EAST FORK JIMMY CAMP CREEK CHANNEL DESIGN CREEKSIDE DEVELOPMENT

Kiowa Project No. 18020
MAY 1, 2019

LORSON RANCH
CREEKSIDE DEVELOPMENT
EAST FORK JIMMY CAMP CREEK
CHANNEL PLAN AND PROFILE STA 10+00 TO STA 22+00
EL PASO COUNTY, COLORADO

**LORSON RANCH
CREEKSIDE DEVELOPMENT
EAST FORK JIMMY CAMP CREEK
GRADING AND EROSION CONTROL PLAN
EL PASO COUNTY, COLORADO**

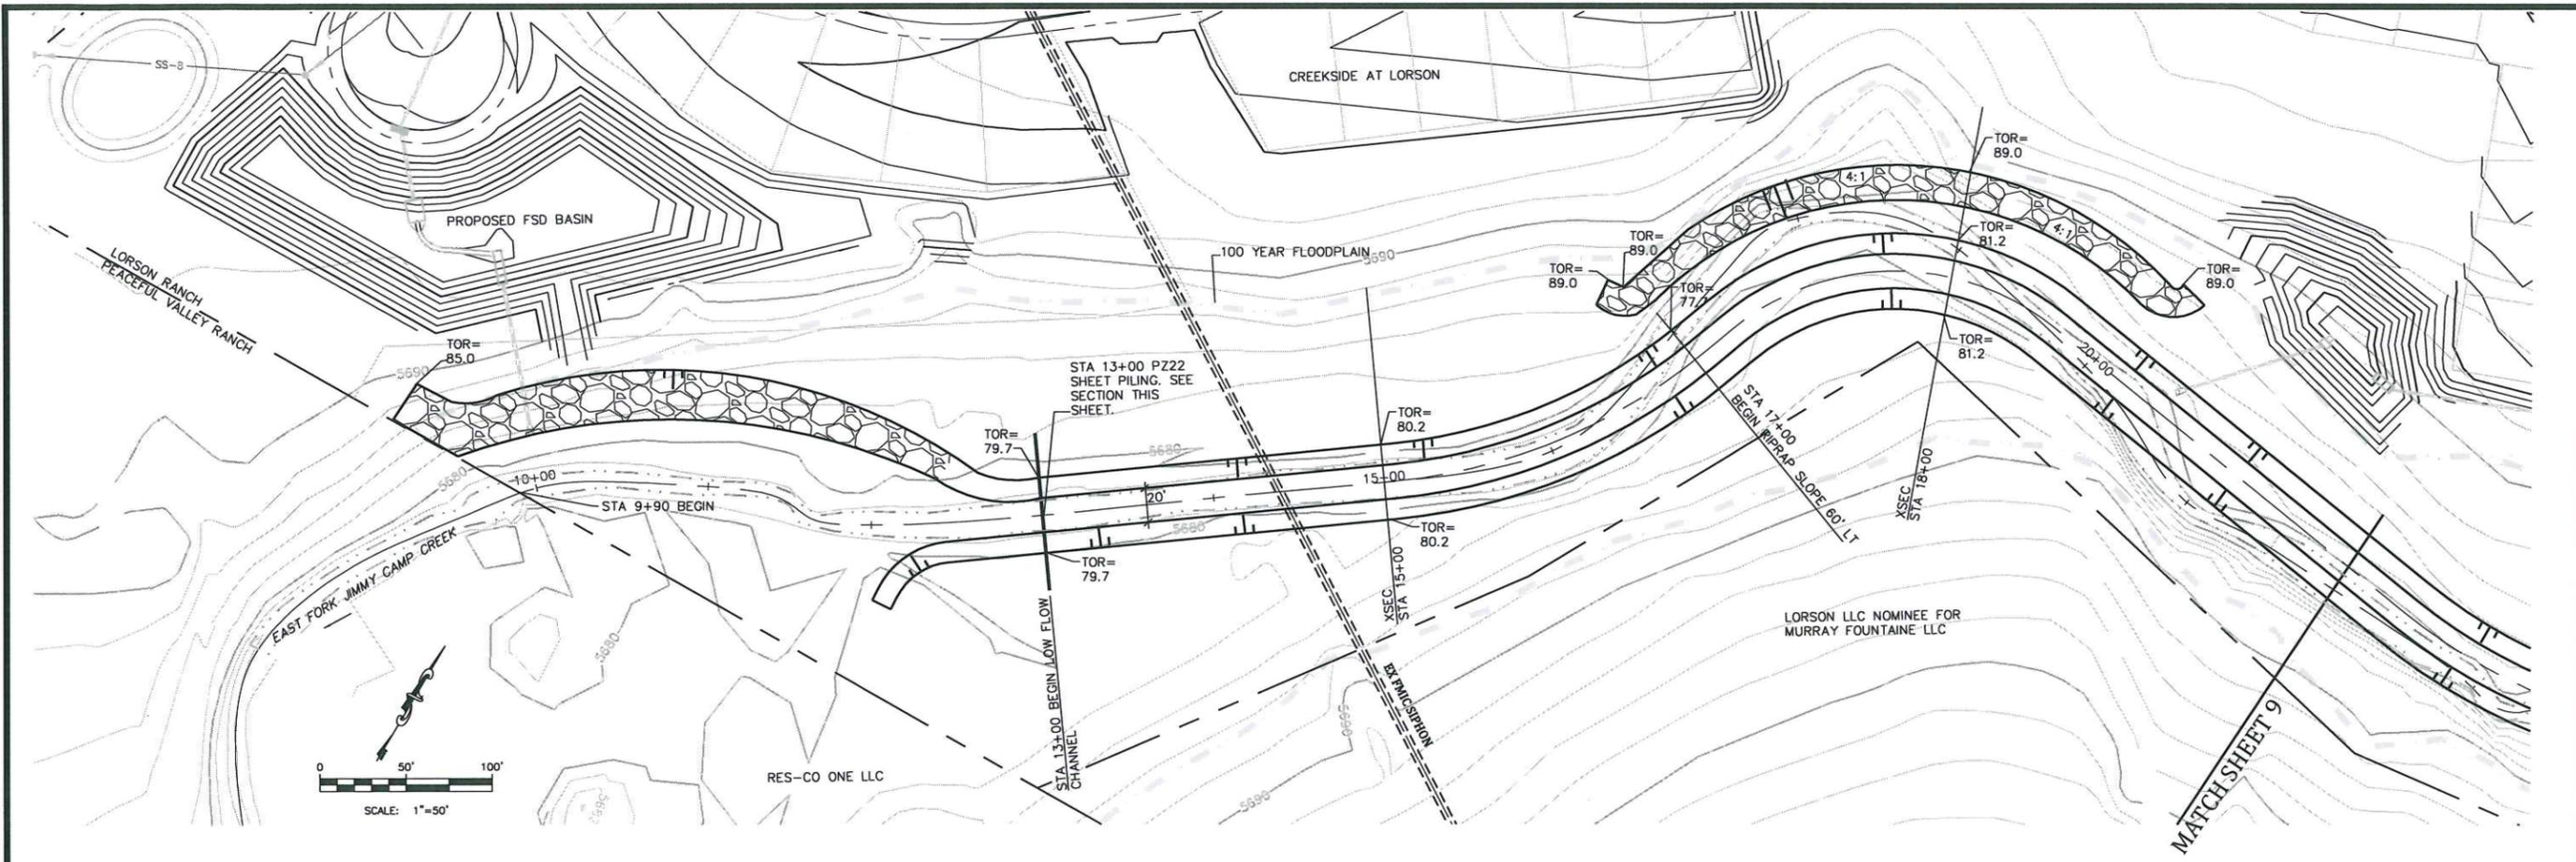
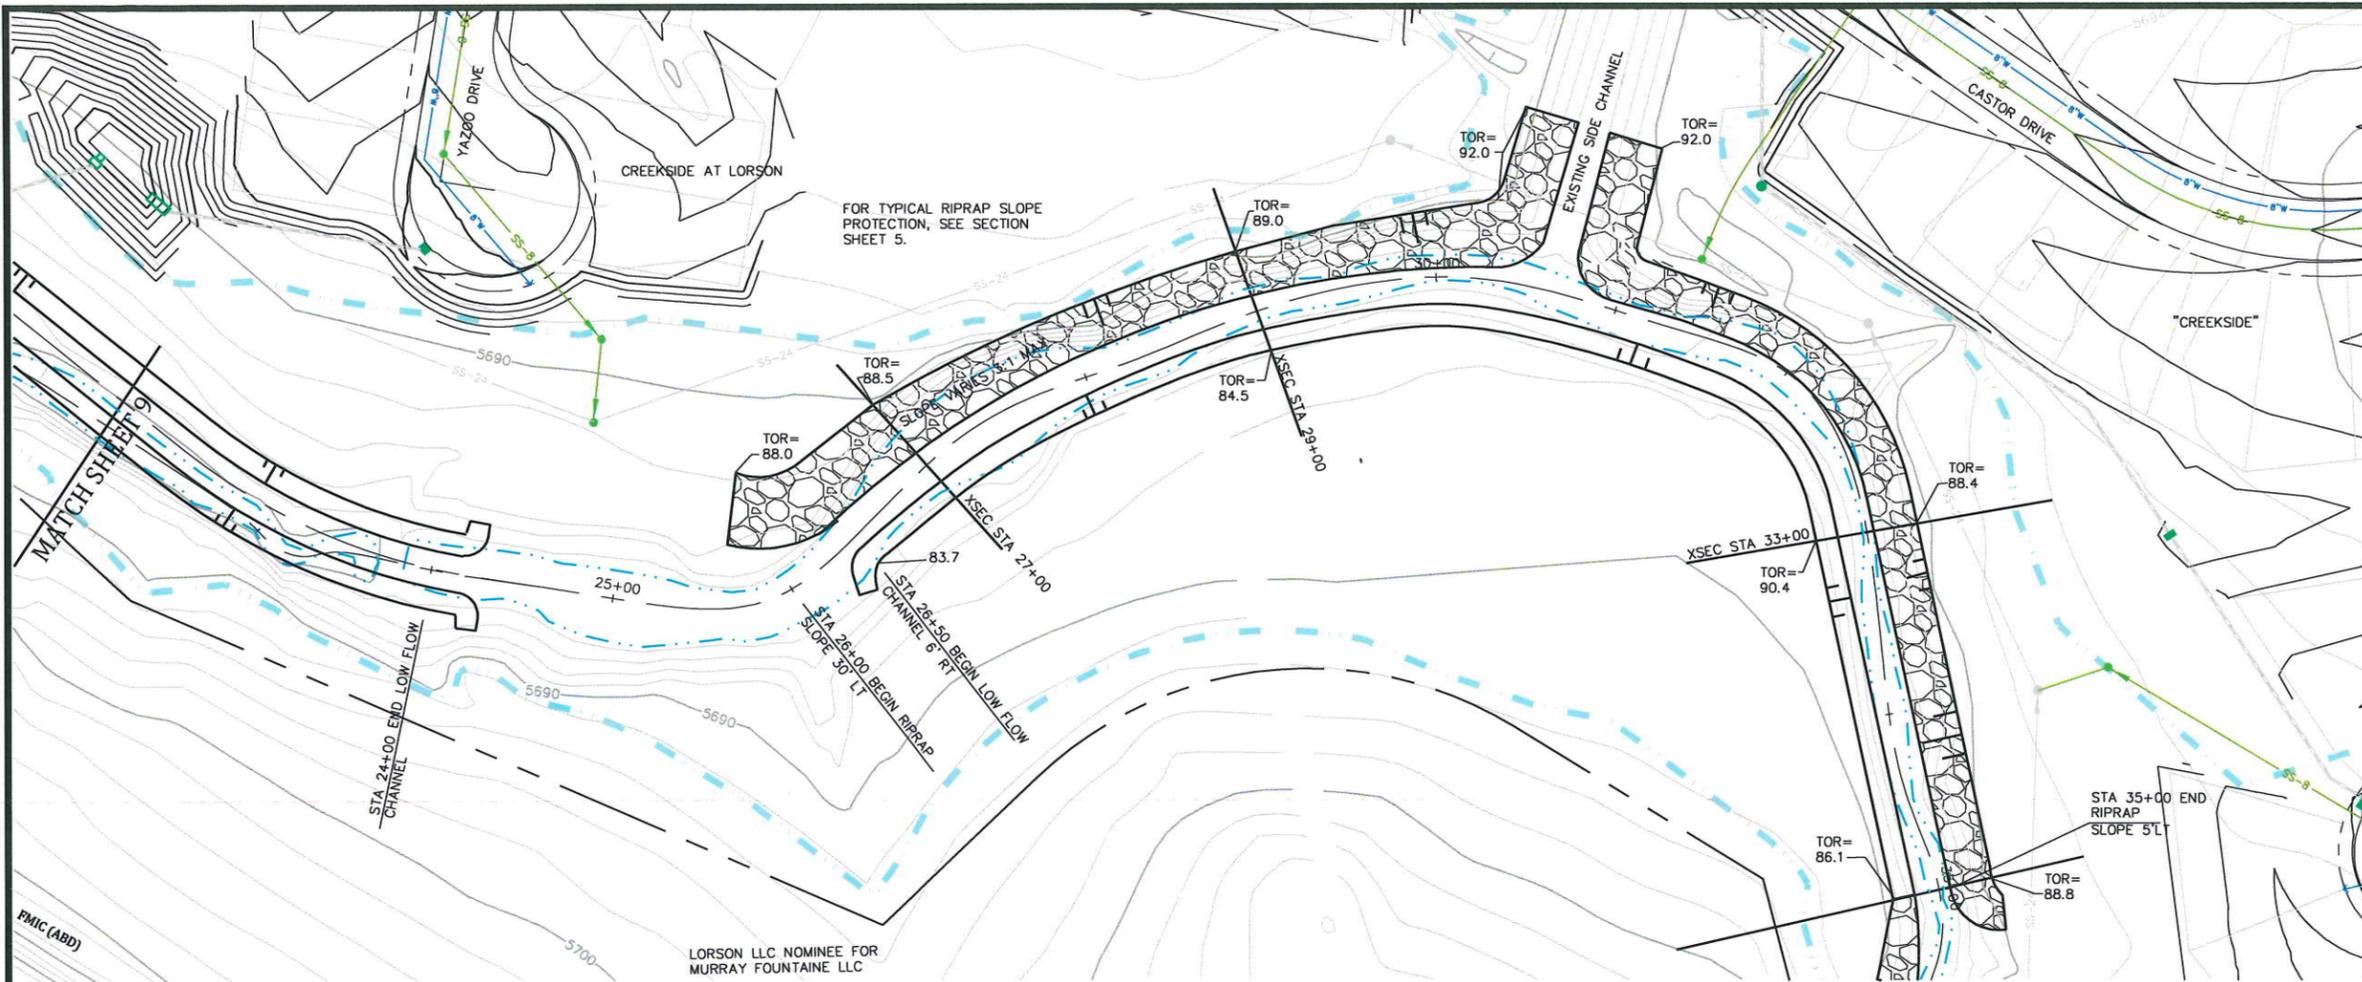
show grading

- Show all proposed contours where grading is required.
- Show and label maintenance access roads/trails.
- Show all erosion and sediment control BMPs
- Show and label seeding and mulching, ECB, TRM, etc.
- If certain BMPs are not being used on these sheets, delete the details - VTC, CWA?
